Date: 01/23/2025

Re: Truss Issues
Location: Lot 279 Altis at Serenity 68 Serenity Crossing (Fuquay-Varina, NC)
JDS Project No.: RDU2500730, RDU2501269
Date of Inspection: 01/23/2025

A representative of JDS Consulting arrived on site to observe the issues reported to us by the client, which are presented, along with our recommendations, in this report.

FOUNDATION PLAN
 5920-06 MODEL
 SERENITY
 MASTER SET
 RALEIGH, NC

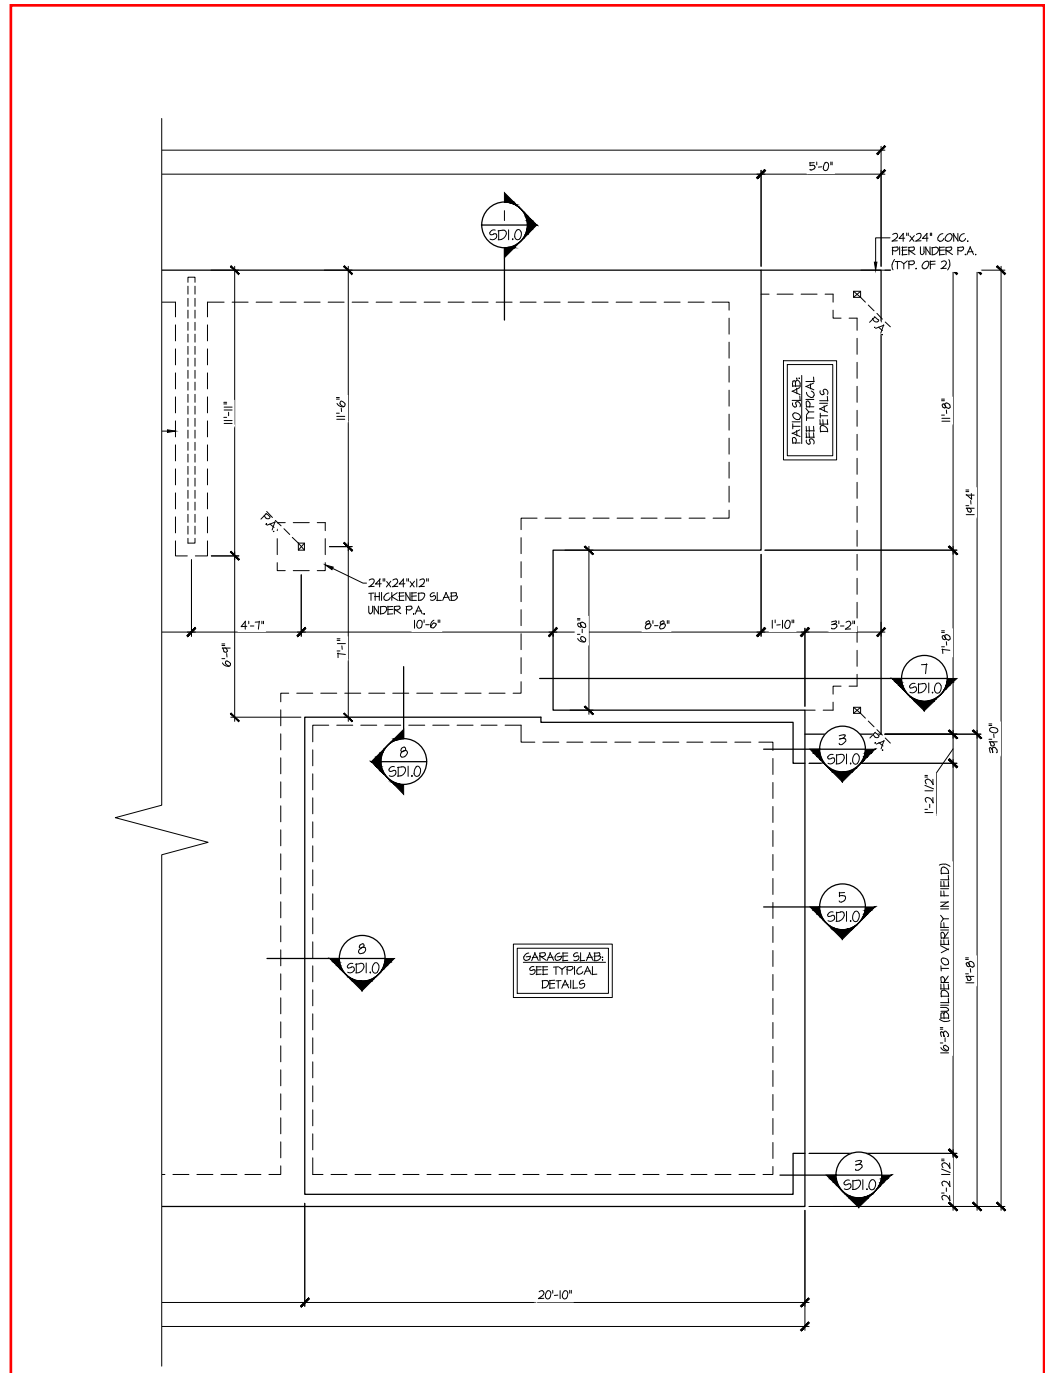
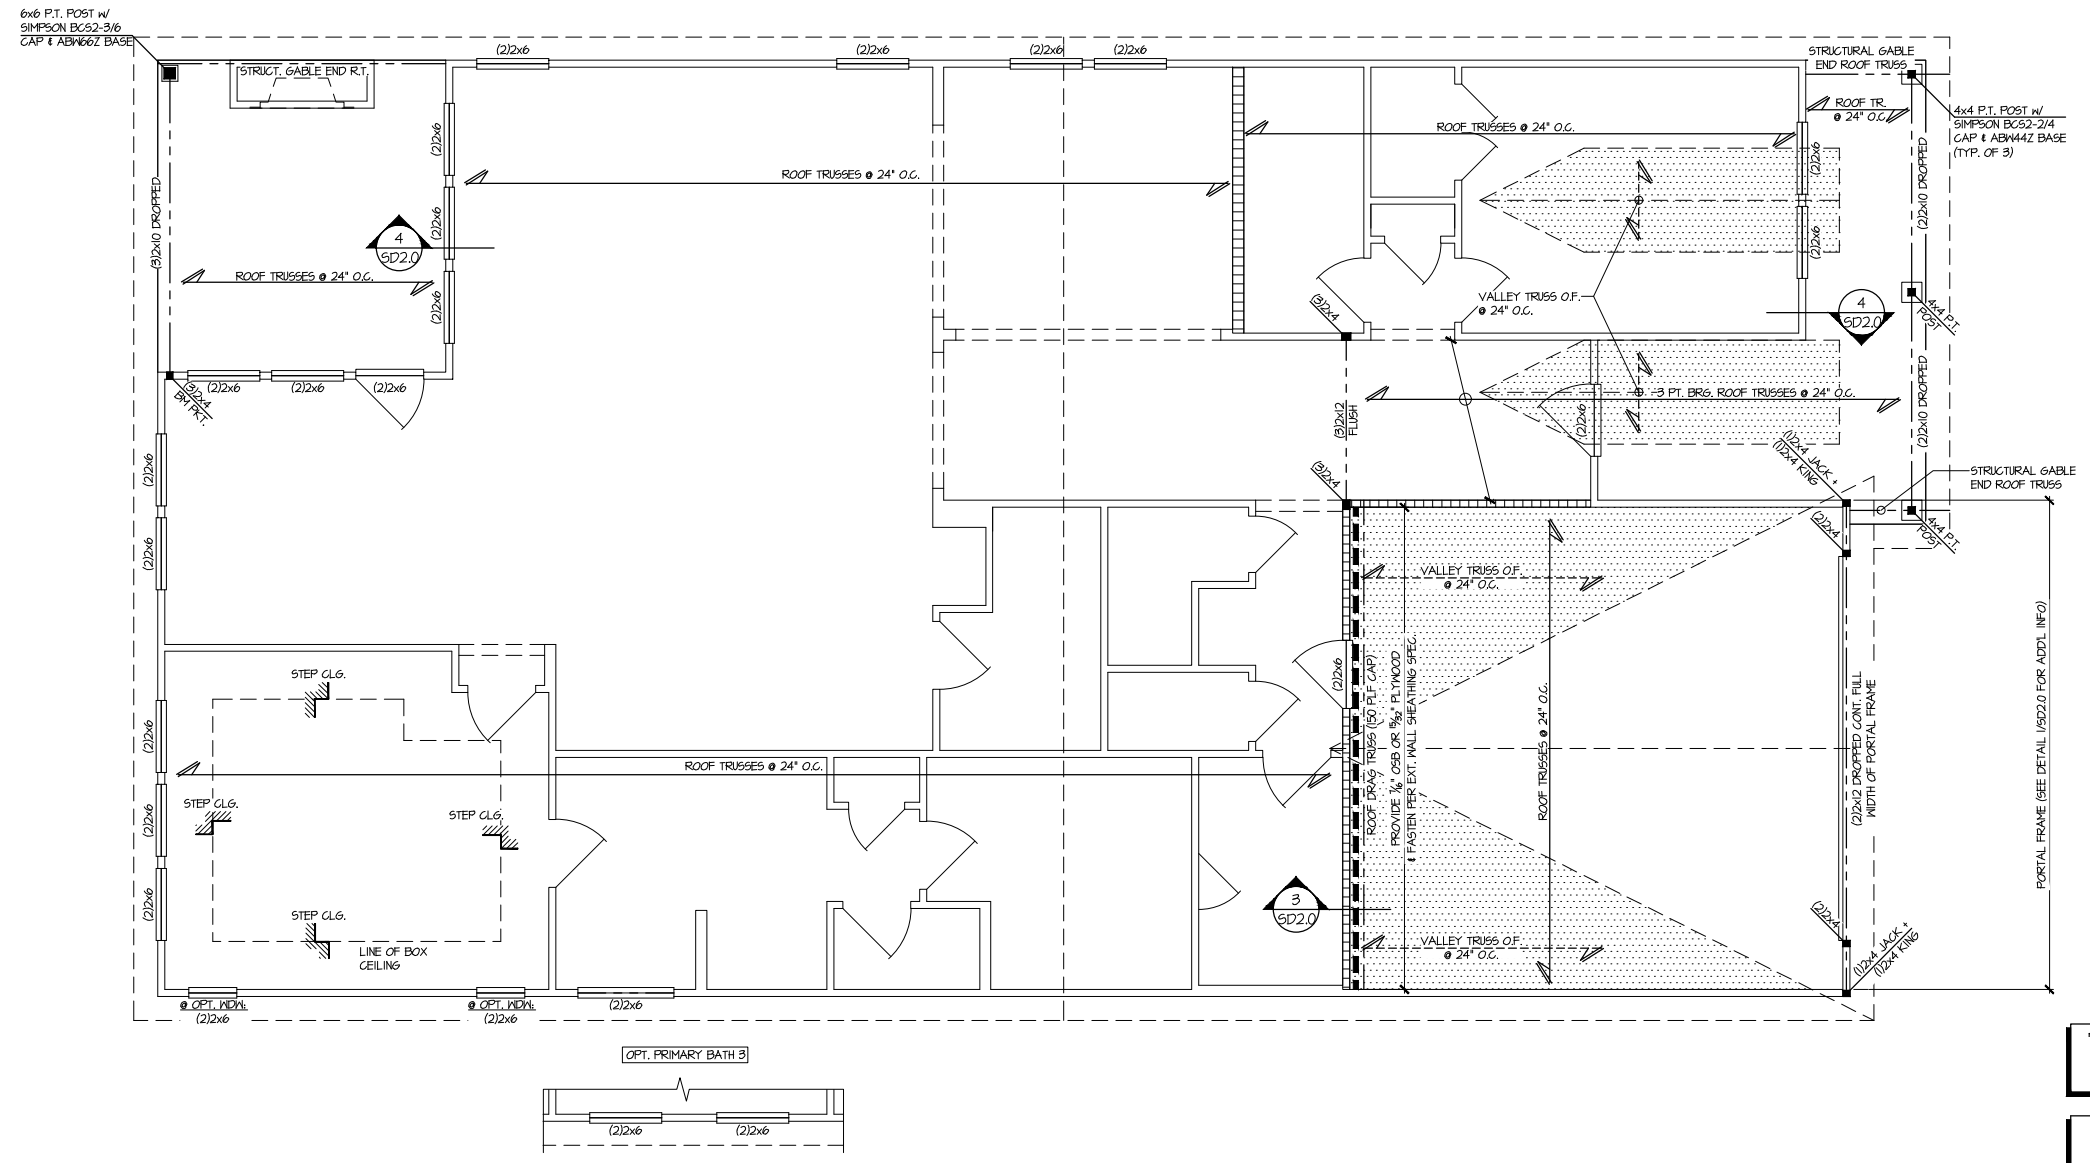
1. The porch beam at the right side of the porch is not flush with the right corner of the house. The beam is approximately 11" short of the edge. Client wishes to extend trusses such that the trusses are flush with the right side of the building.
2. The drag truss at the rear of the garage does not bear on the rear wall, it bears to the front of the wall by approximately 12". The client wants to extend the slab and move the wall to bear directly under the drag truss.
3. The mechanical room in the 2nd floor was assessed for adequate clearance for installation and serviceability. The mechanical room is approximately 76" x 76"
4. The B01 trusses located 1st through 5th to the left of the B01A truss need to be modified for HVAC clearance.

2. Extend the slab and footing with the following steps:
 - a. Excavate at the front of the existing wall down to the bottom of the footing, creating a clean-cut face.

- b. Remove all loose dirt and debris from the slab extension area.
 - c. Ensure the footing depth is maintained and installed per detail SD1.0-8.
 - d. Where the slab is cut (approximately 4"+ off the face of the new wall) prepare a minimum 4" thick slab with 6 MIL vapor barrier. Tape the vapor barrier to the existing one where possible.

- e. On all sides of the repair area, dowel and epoxy (1) row of 8" long #4 rebar horizontally at the mid depth of the slab spaced 16" o.c. The rebar is to embed approximately 4" into the existing slab and have approximately 4" projection into the new slab area. At the footing install an additional (2) rows spaced at 16" o.c. with a minimum 6" of projection into the extension area.

- f. Prior to epoxy, clean all dowel holes with compressed air and/or a wire brush. Ensure enough 2-part structural epoxy (Simpson SET-3G or equivalent) is used so it is visible after rebar is installed for inspection.

- g. Before placing a minimum of 3,000 psi concrete, the client shall ensure the repair preparation has been inspected and approved.**
3. The Mechanical room has been constructed per the plans provided no repairs are required.
